Please ask for: Nicola Moore
Email: nicola.moore@arun.gov.uk
Telephone: Ext 37944
Our Ref: BN/37/22/T
Your Ref:
Date: 25th March 2022

Application for Works to Trees(s) subject to a Tree Preservation Order(TPO)

Location: Land West Of Green Acres Lake Lane Barnham PO22 0AE

Project title Land at Lake Lane Barnham, West Sussex			
Drawing title Tree Retention and Protection Plan Tree Works Application			
Scale 1:250 @A1	Drawn GS Approved JJ	Date 16.03.2022	Revision 00
Drawing No LLD1532 / 01 CAD Filename LLD1532 / CAD			Revision 00

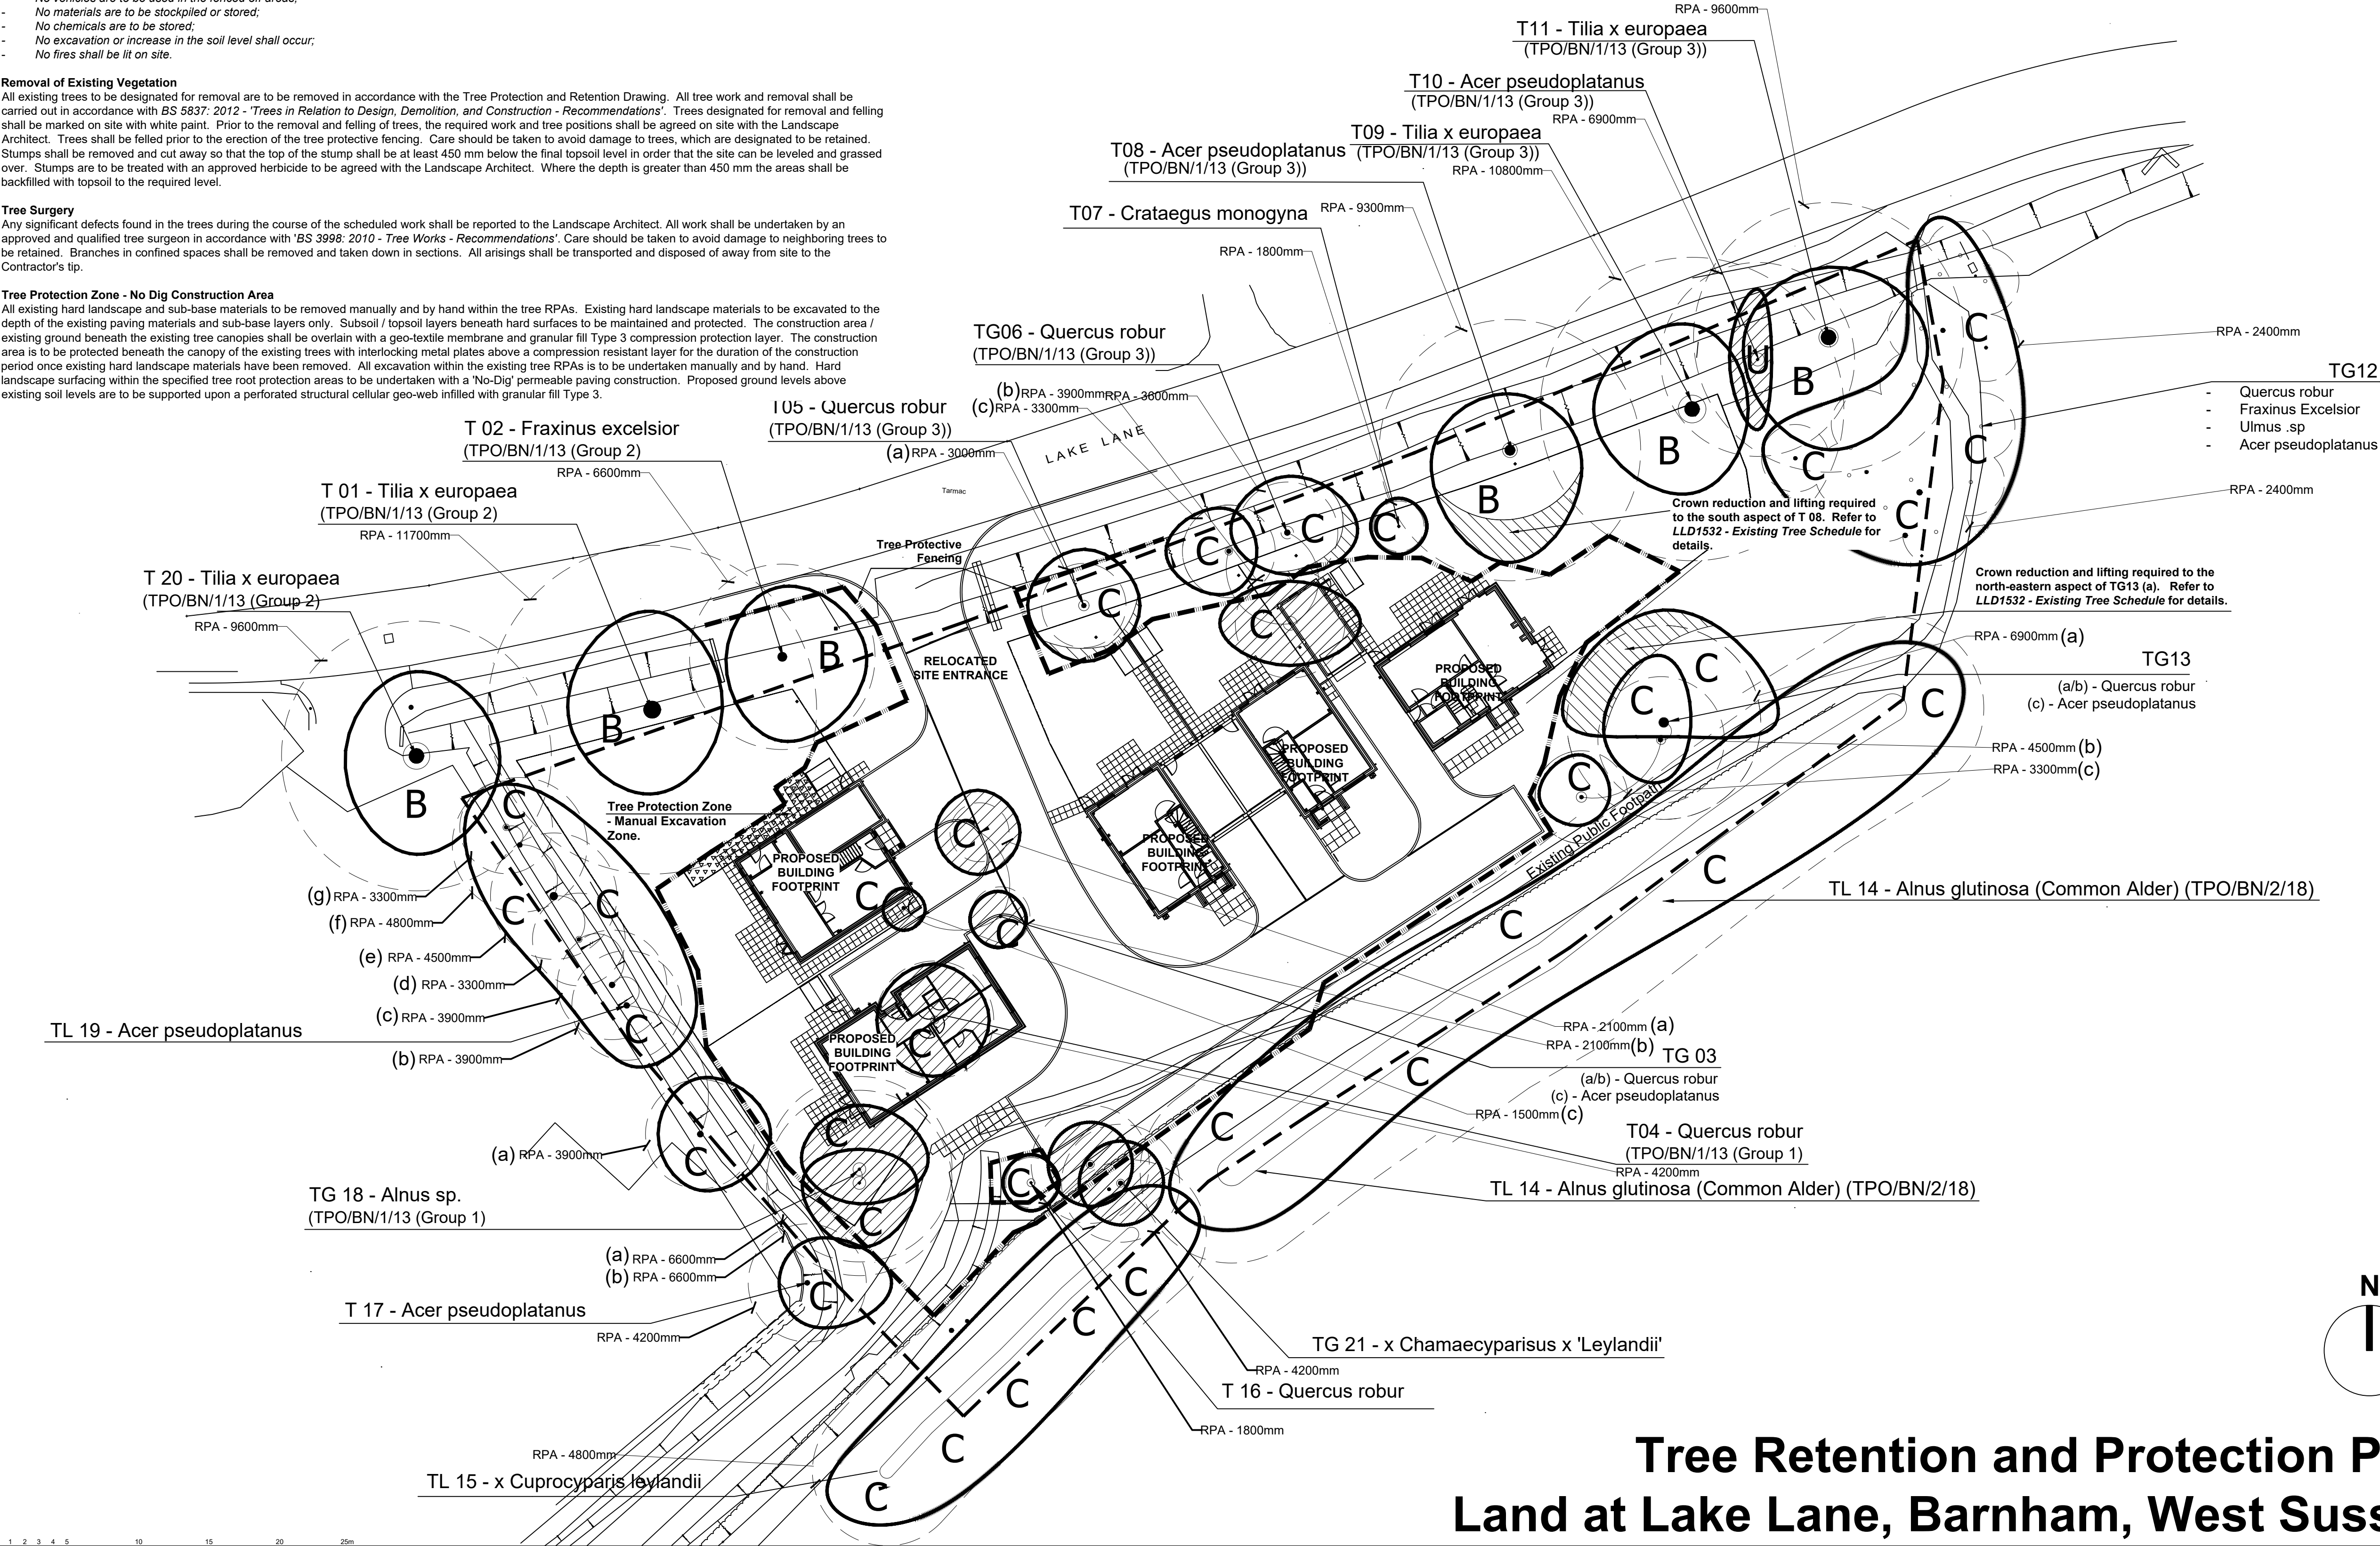
Please provide the proposed height and spread measurements, in metres for T08 and T13a, rather than the amount being removed.
